Submission Form

Epping to Thornleigh Third Track Proposal. Application number SSI 5132.

Figure S.5 Artist's impression of new elevated concourse at Cheltenham Station looking south from The Crescent (indicated by dot)

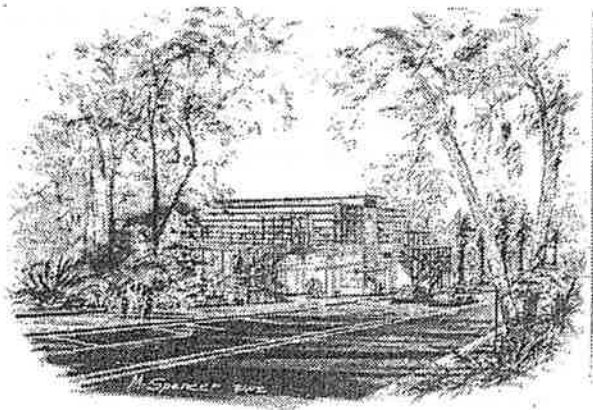
- The proposed redevelopment of Cheltenham Station shows no regard for the HCA. The visual impact of the proposed 13m high glass and steel concourse is totally unacceptable in this HCA.

Figure 5.3 Future Cheltenham Station layout

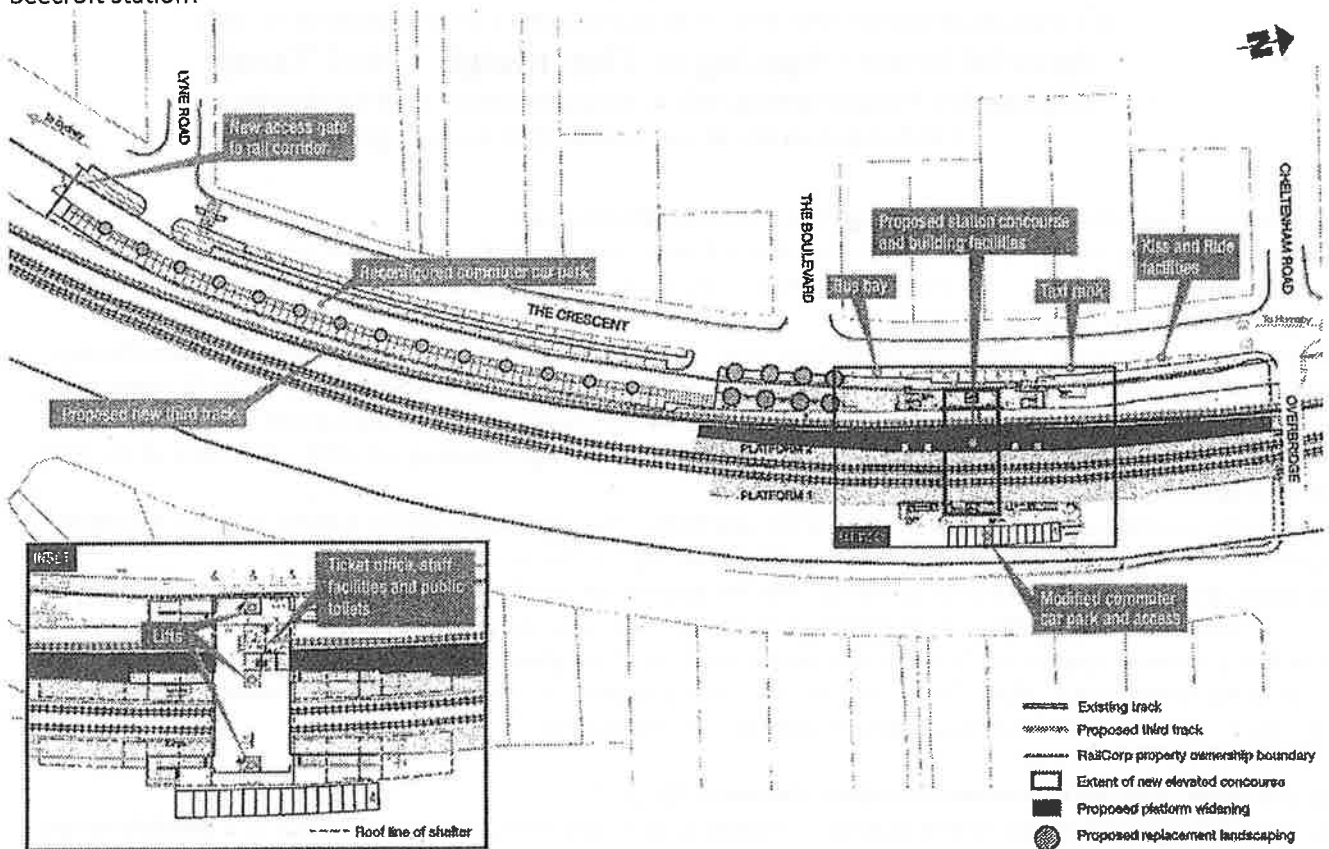
- There has been inadequate assessment of the project's impact on the fabric of the Beecroft Cheltenham Heritage Conservation Area (HCA).
- The plan given for Beecroft Railway station Precinct is vague. The relationship to the trees, playground and original 1895 platform located south of the present station is not shown. A fourth track is shown on the eastern side. The plan does not include urgently needed lifts to allow disabled access at Beecroft Station.
